Whalley Parish Council

PLANNING APPLICATIONS

| GT | 3/2011/0714 | Proposal: | Non-illuminated sponsorship acknowledgement sign |
| | | Location | Junction A59/A671 roundabout |

*RV3 - A59/A671 -
Accrington Road R/but*

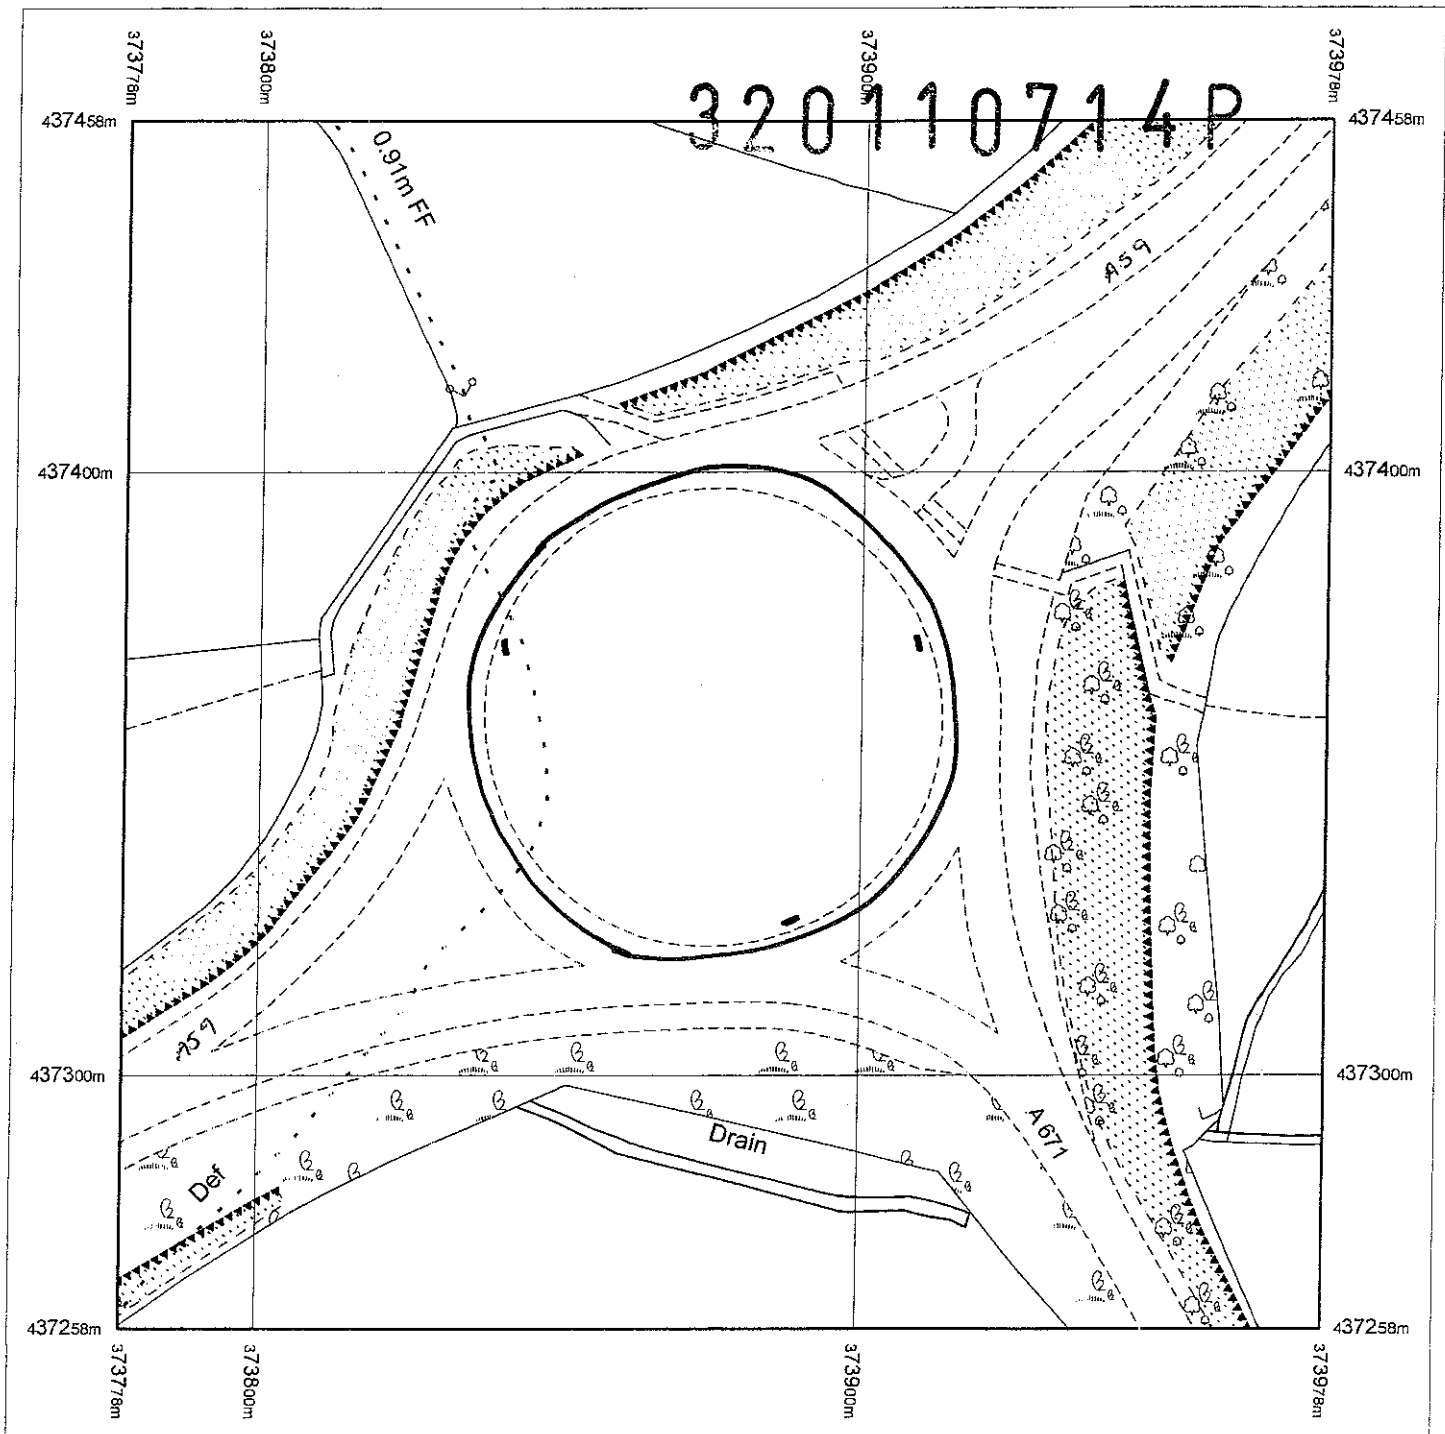
| | | Observations | Despite the LCCs Principal Engineer stating that the displays "are not likely to obscure, or hinder the ready interpretation of any traffic signs" it is the parish councils considered opinion that motorists will be confused and that erection of such displays will increase the potential for accidents. |
